From: Dafydd Lloyd
Sent: 18 September 2014 09:31
To: Peter Cleveland; Sue Howell
Subject: RE: Hollyacre Toddington - Ref: LU/234/14/DOC

Please find attached the proposed tree protection plan which seeks to discharge Condition 8 of the planning approval LU/116/13 which is a scheme for 63 dwellings in Littlehampton.

As discussed drawing L(90)1000 attached to indicate more clearly the tree protection.

Drawing Title  
Tree protection - Phase 1

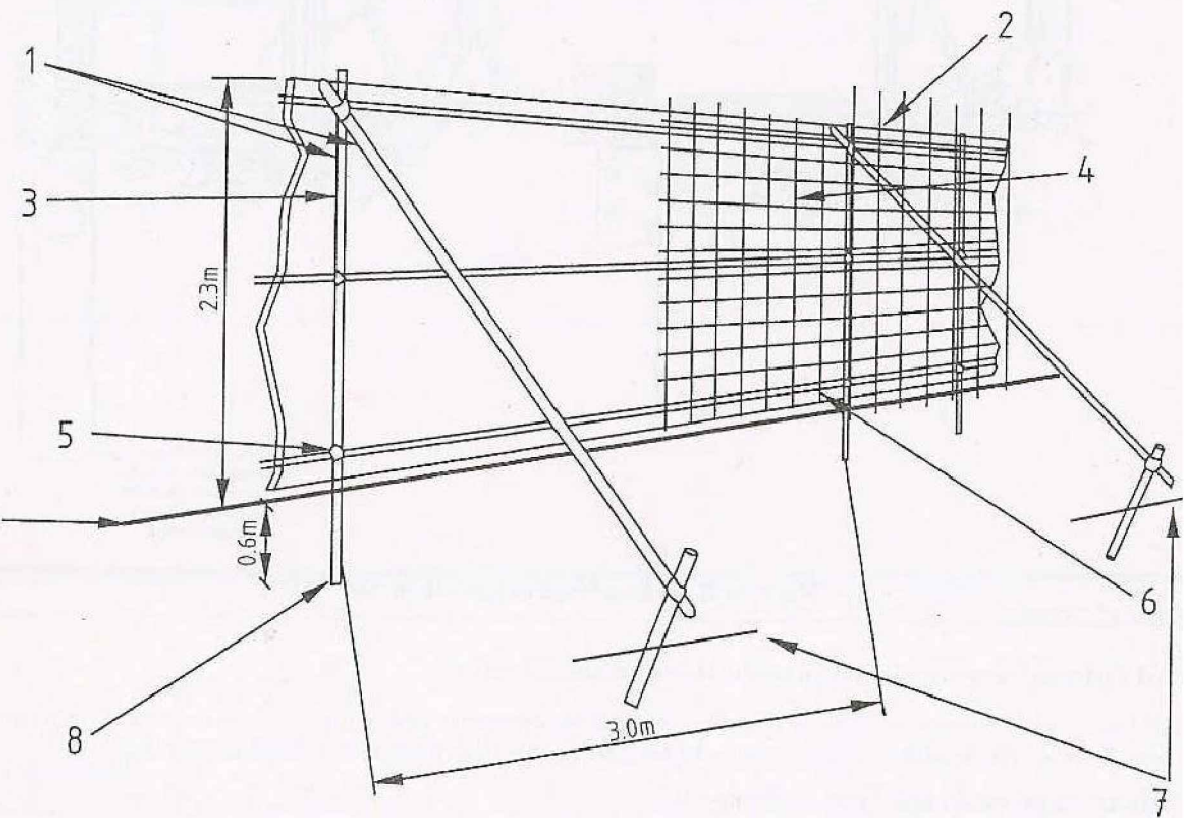
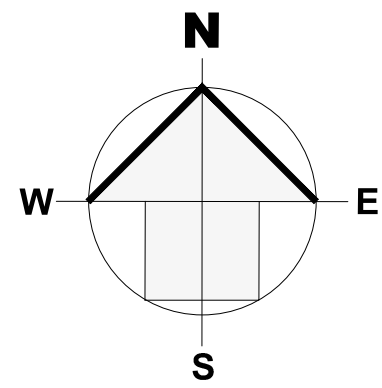
Just gone through this, and all this is the method of B55837 without any content. All the applicant has done is provided the methods of a surveying, categorising, retention, and then mitigation of these trees without the application of any tree data from the site. The applicant needs to actual produce the data from the surveying. Once the surveying is done a retention and mitigation plan can be produced. The applicant has failed to do this. For these reasons I cannot even comment on this application, as there is no data to comment on. **This is therefore a refusal from me.**
